DECISION DELEGATED TO HEAD OF PLANNING

Application No:	H11-0726-22	Applicant:	Mr K Bunn
Proposal:	Conversion of snooker room into 2 bedrooms to be rented out to general public (no breakfast will be provided)		
Location:	Churchills West Street Long Sutton		
Terminal Date:	19th October 2022

FIRST FLOOR PLAN

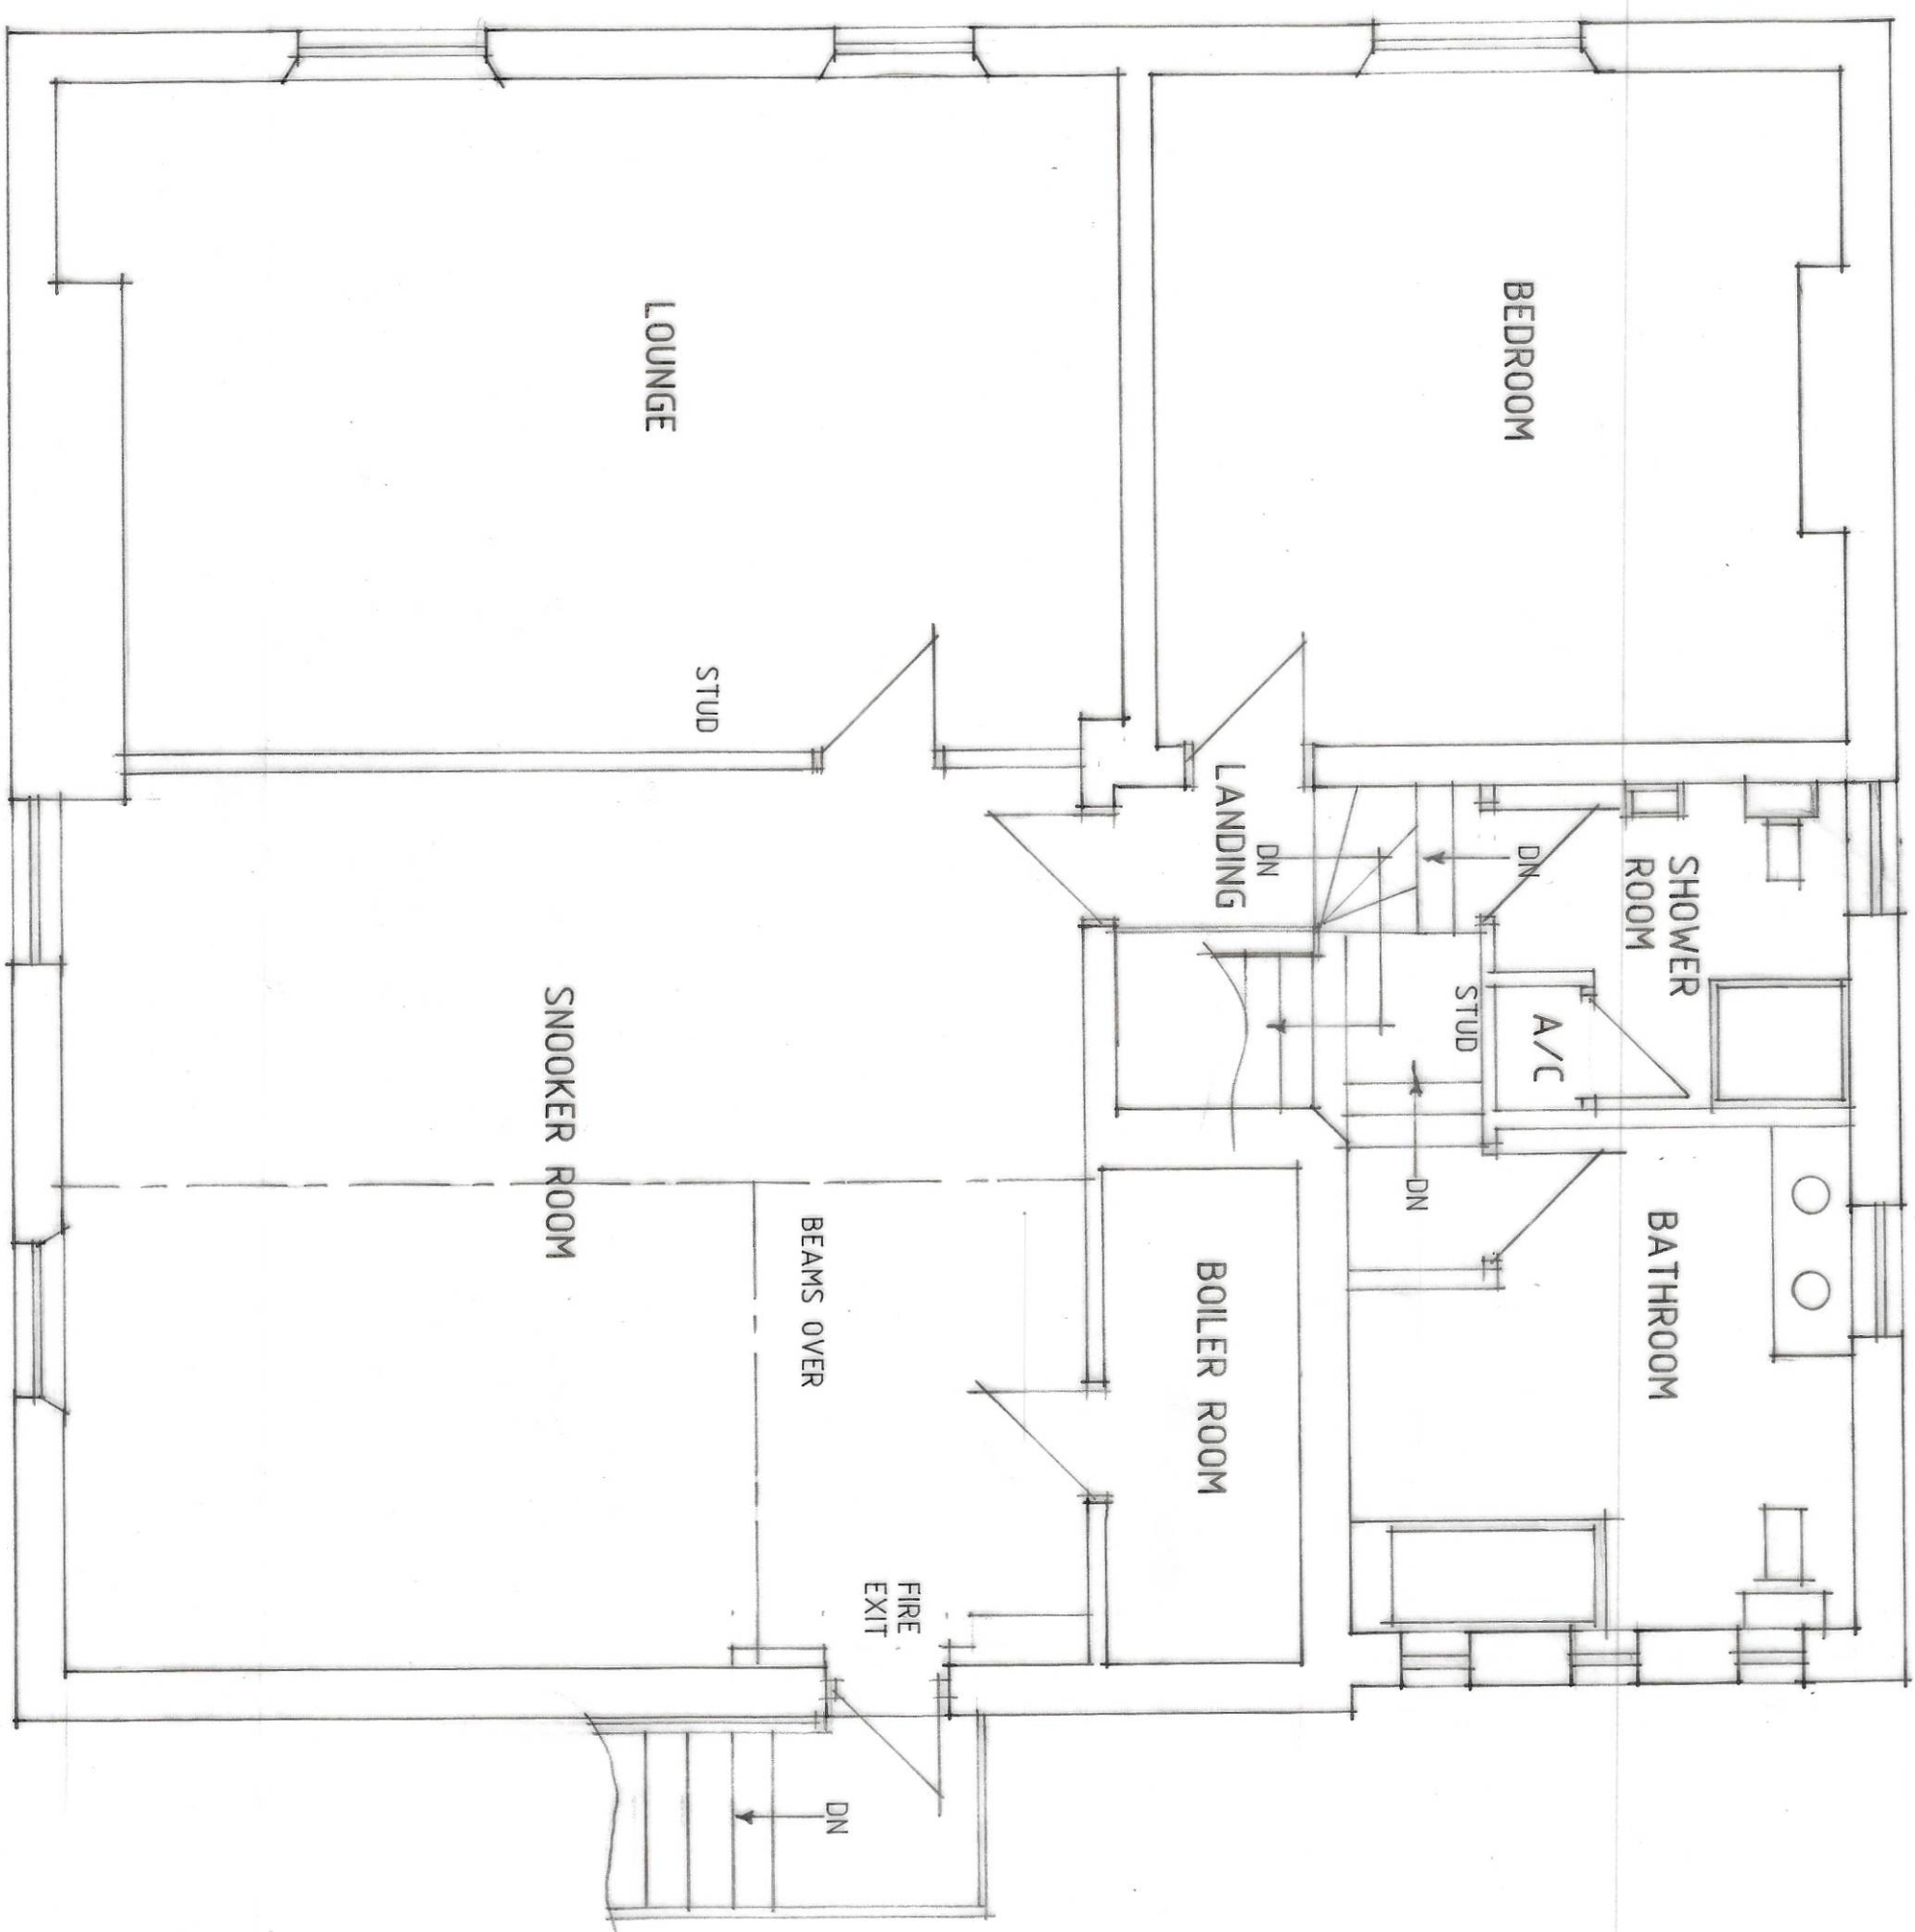
The proposal involves minor internal alterations and a partial change of use on the Grade II listed. The internal alterations include the subdivision of the existing snooker room by the insertion of a new north-south orientated and bisecting internal stud partition wall along with a second east-west aligned internal stud partition wall, (within which will be inserted two new south facing entrance openings that will lead onto the new first floor hall).

No objections as the proposed use of stud walls to subdivide the existing snooker room should be fully reversible should any future custodian of the property wish to restore the extant layout.

The Council's Conservation Officer has not raised any objections to the proposed scheme and considers that no loss of significance is risked by the proposed scheme as the proposed use of stud walls to subdivide the existing snooker room should be fully reversible should any future custodian of the property wish to restore the extant layout.

SITE PLAN

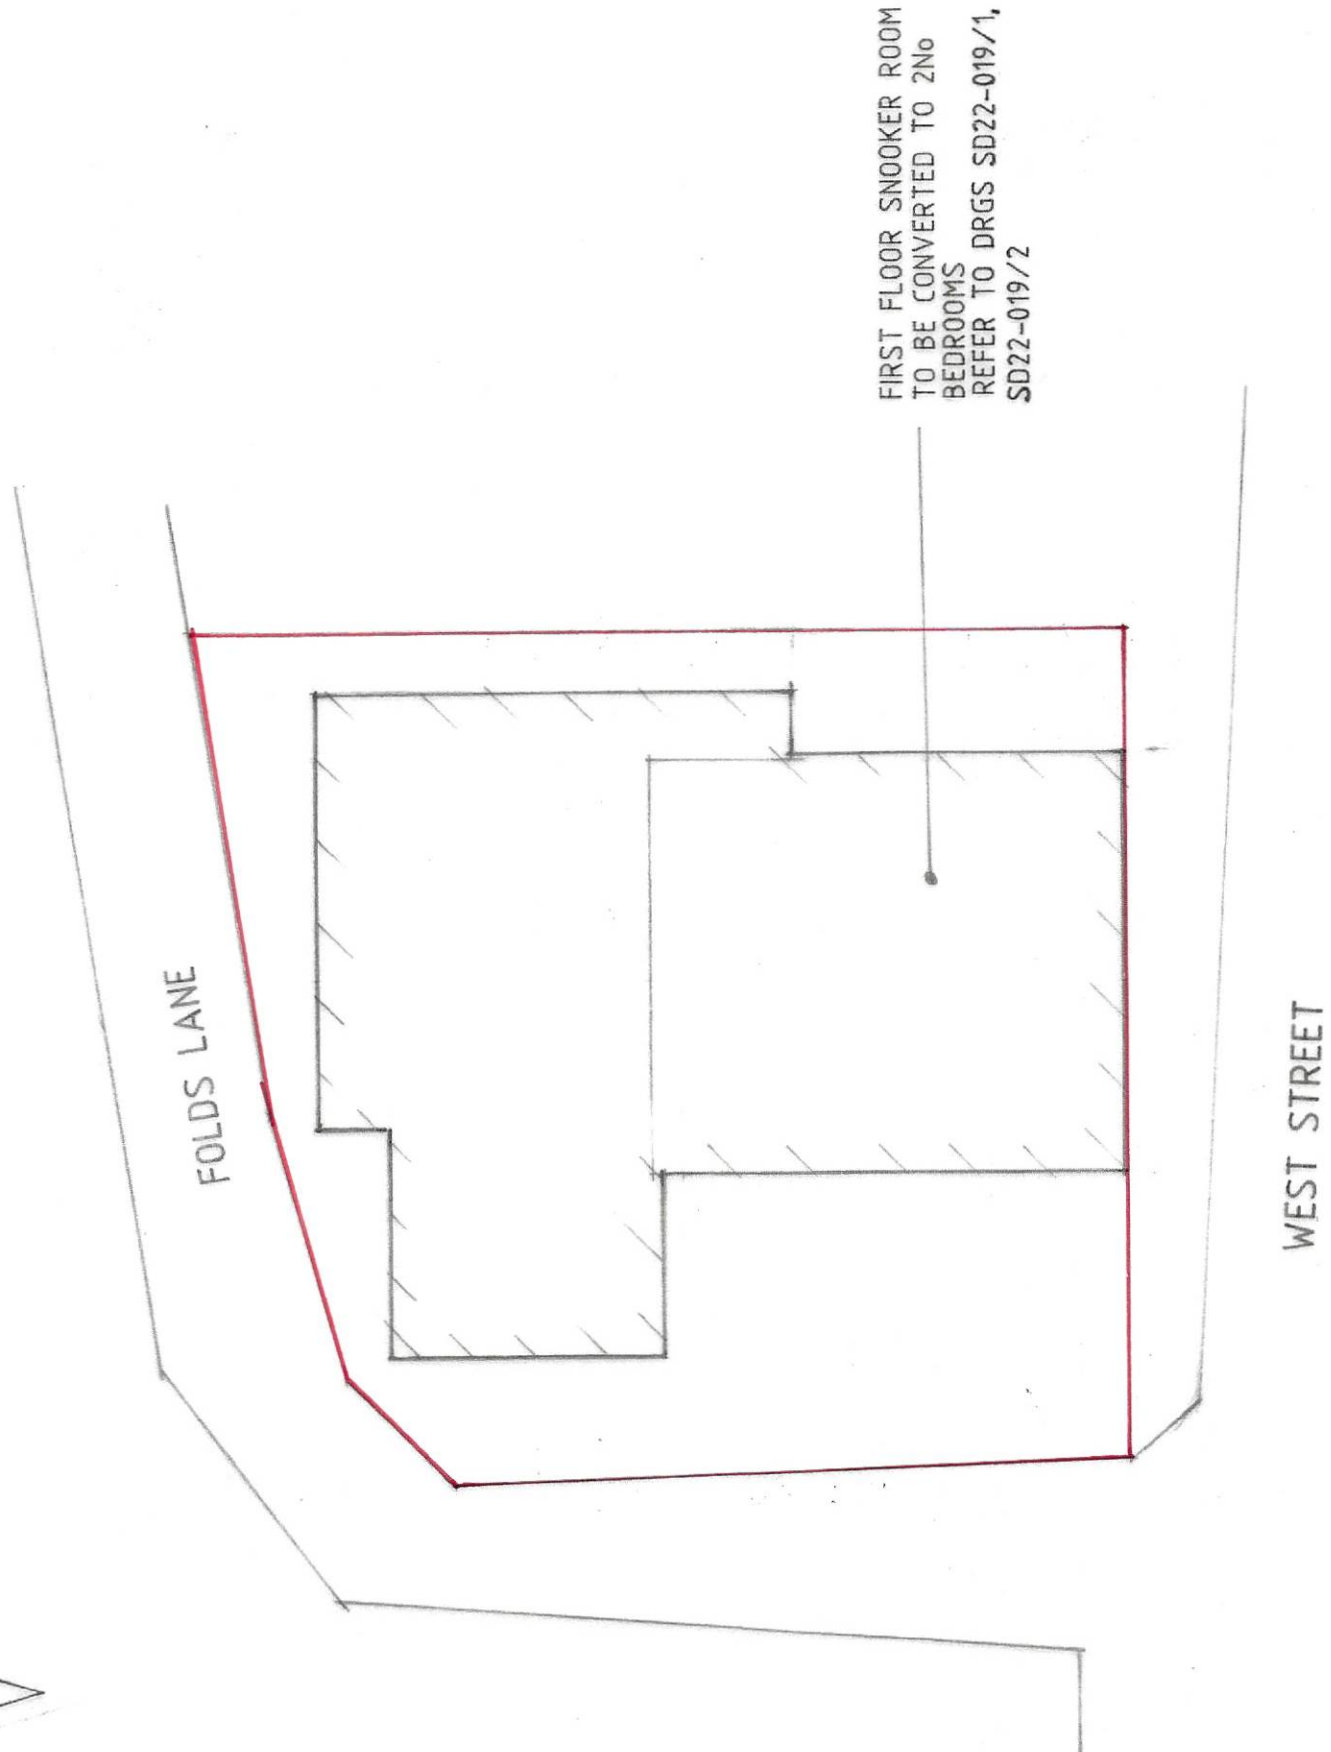
The site does not have any provision for off-street parking therefore the development would not meet the current parking standards. As such it would result in highway safety issues and a cluttered street appearance due to additional vehicles being parked on the road.

Despite no objections from the Local Highway Authority the proposal is considered contrary to current parking standards. Given the site is not able to demonstrate on street parking provision for the proposed B&B in line with the current parking standards set under Appendix 6 of the SELLP the proposal would result in vehicles associated with the new use being parked on the street which would result in road safety concerns and a cluttered street appearance due to additional vehicles being parked on the road.

The agent has suggested that they could secure parking at another property the applicant owns at Long Sutton Tyres, Park Lane, Long Sutton, PE12 9DH. However, as this site is located some 400 metres from the application site it would not be practical. In addition, as this site is outside the application site boundary the site cannot be controlled in planning terms.
